# Rezoning Transportation Analysis

Petition Number: 2023-043

**From: Jake Carpenter, PE**

**RZ-1**

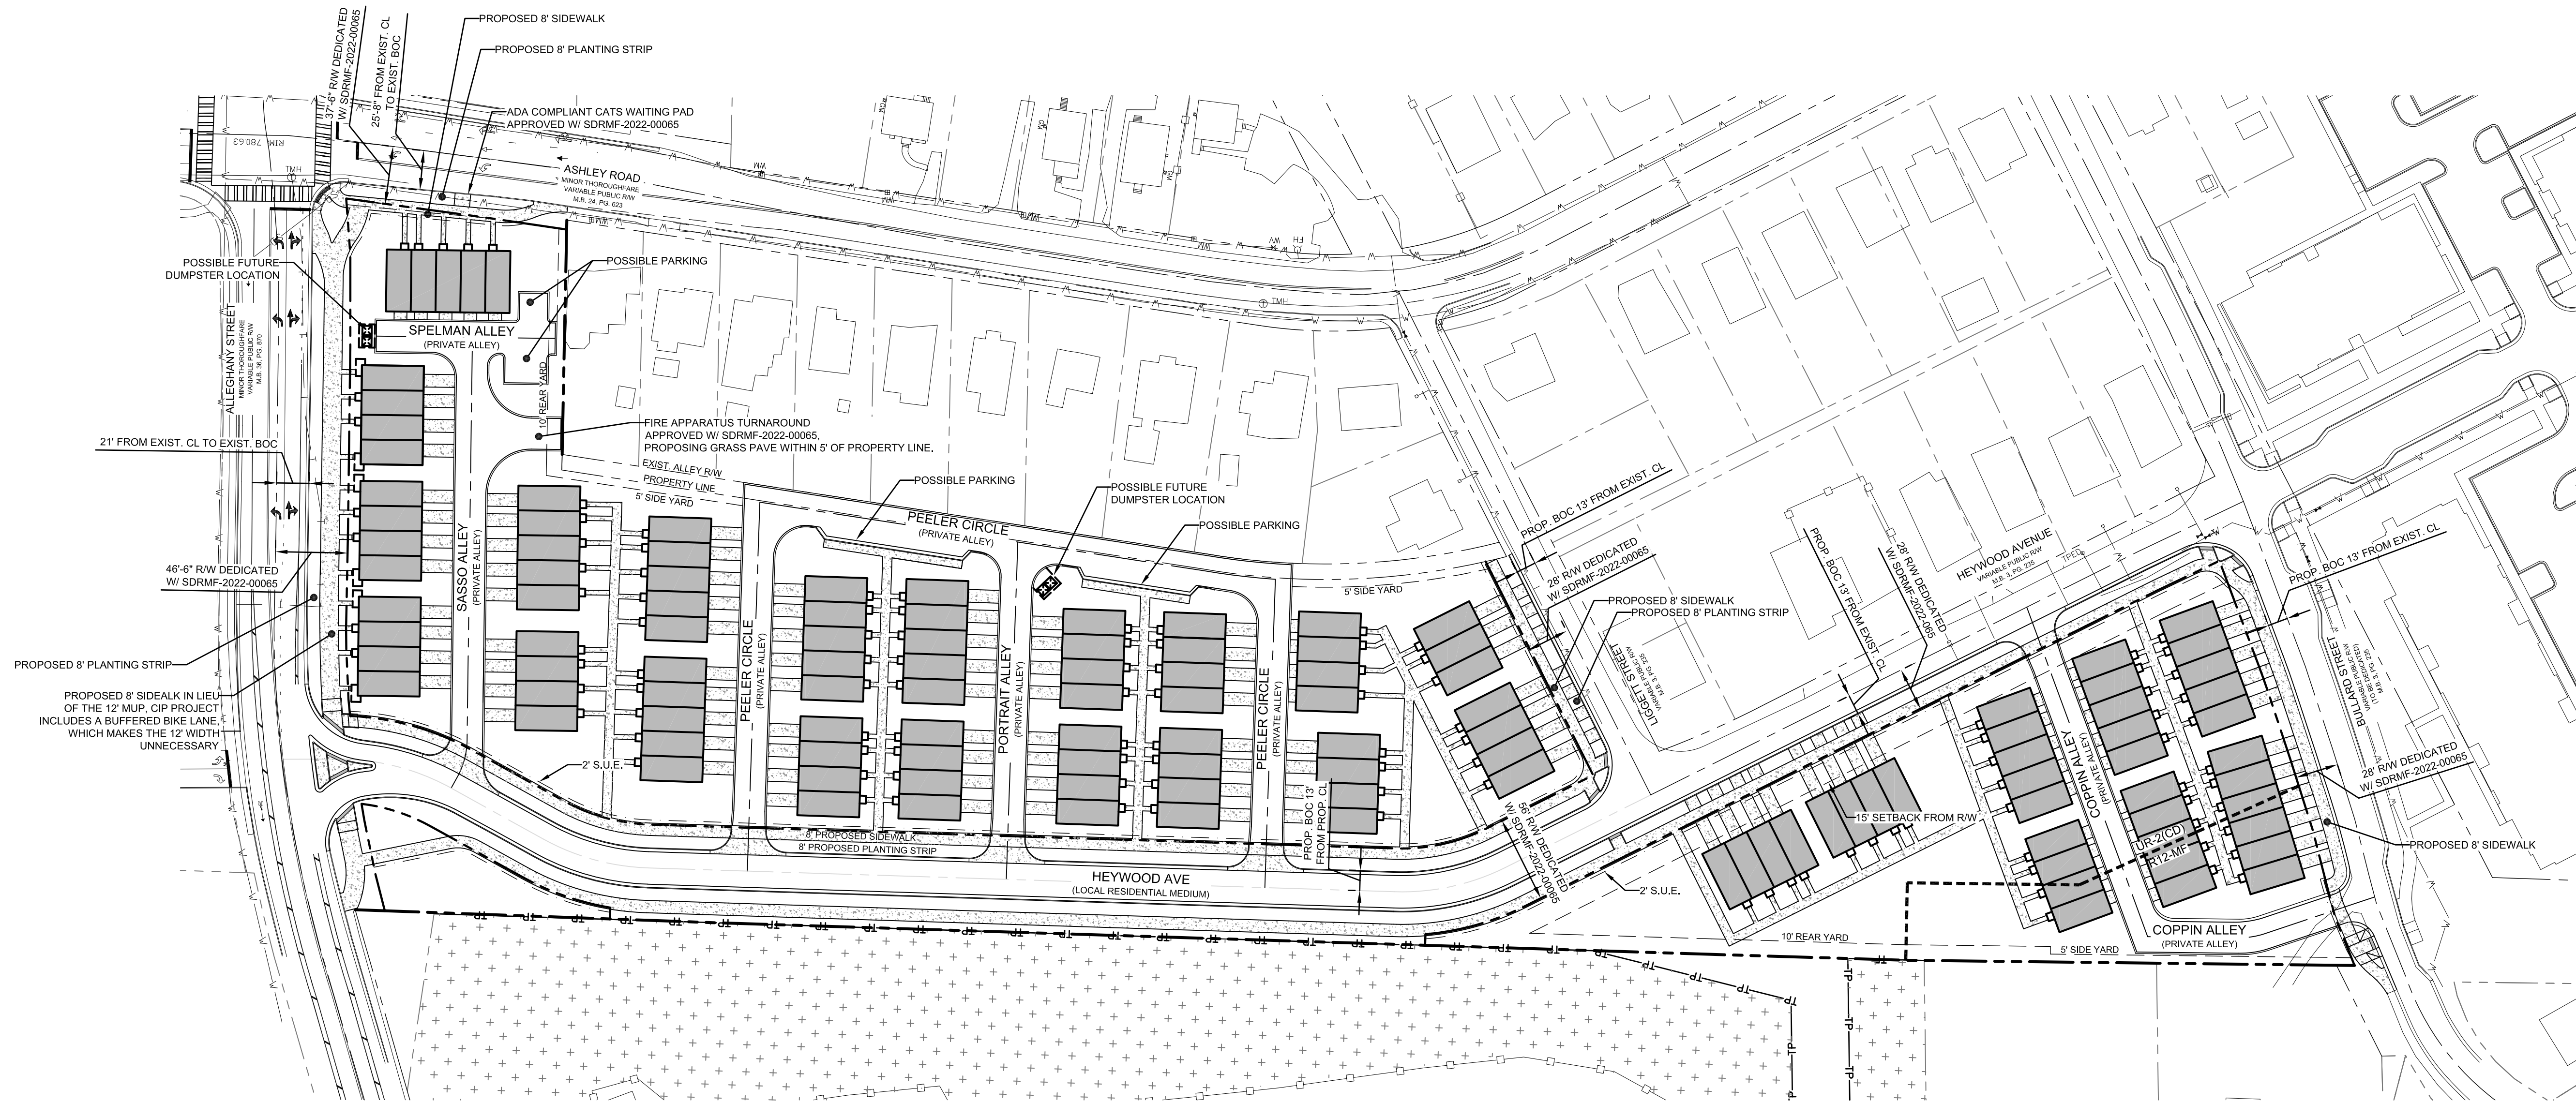
- a. **Proposed Public Street A:** New local residential medium street, back of curb located 13' from the centerline.
- b. **Alleghany Street:** Future back of curb located 27' from the centerline to accommodate a roadway cross section of a 2+lane avenue with buffered bike lanes.
- c. **Ashley Road:** Future back of curb located 21.5' from the centerline to accommodate a 2 lane avenue with buffered bike lanes.

**Clarifying Comment 9-20-23:** Label and dimension the future curb and gutter from the centerline for each road on the site plan.

**Clarifying Comment 10-23-23:** Label and dimension the future curb and gutter as stated under Curblines from the centerline for each road on the site plan.

**Clarifying Comment:** Remove conditional note 5 and leave conditional note 8. Conditional note 5 commits to dedicating right of way based on phasing. The site plan does not specify phasing of project, the transportation improvements will need to be completed in entirety unless the site plan specifies phasing that CDOT agrees to.

~~6. **Outstanding Comment from 7-26-23:** Revise site plan and conditional note(s) to remove the fence completely from the public alley and onto private property. If fence is to remain along the single family home side it needs to be completely on private property.~~

Fence was removed from site plan
